**Consultation Response from KC,
Trees****2020/93954 Land at, Lingards Road, Slaithwaite, Huddersfield, HD7 5HY****Erection of 43 dwellings and associated works****Date Responded: 27/01/2023****Responding Officer: M Moss****Responding Ref:**

DRAWING 1 – RESULTS OF EXTENDED PHASE 1 HABITAT SURVEY

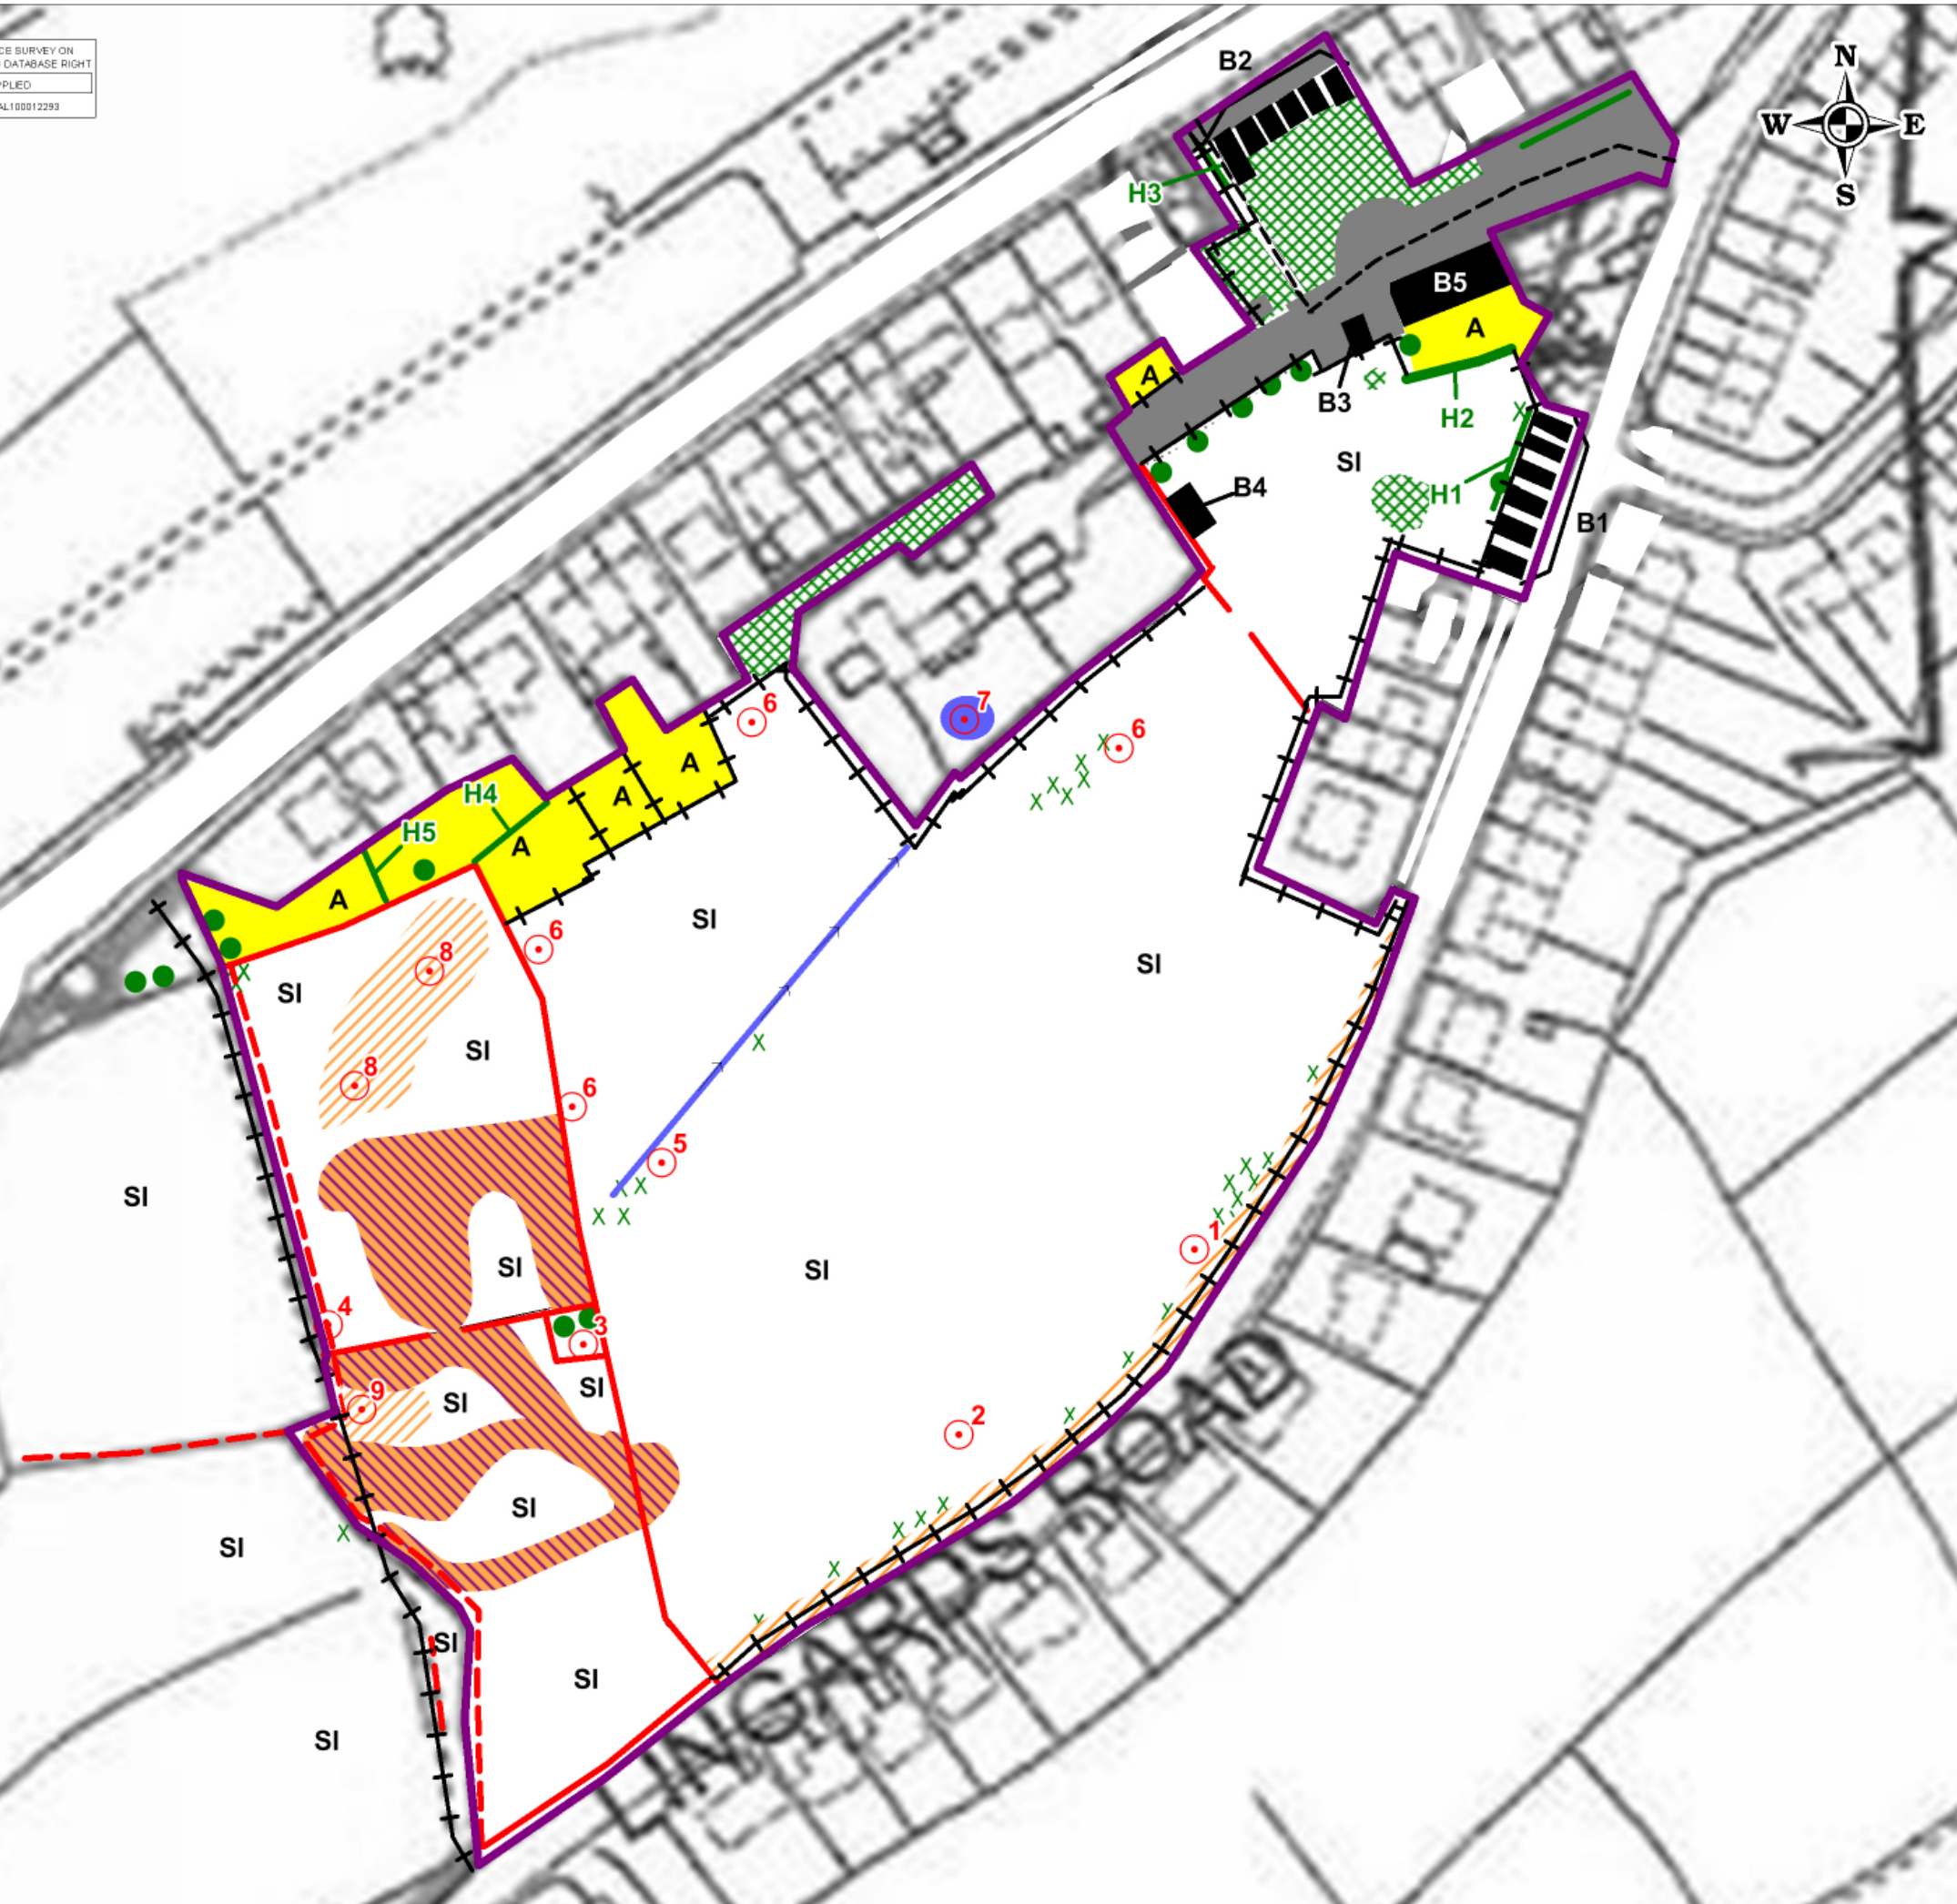
All significant trees within and along the perimeter have been shown as retained and mostly designed around which is good.
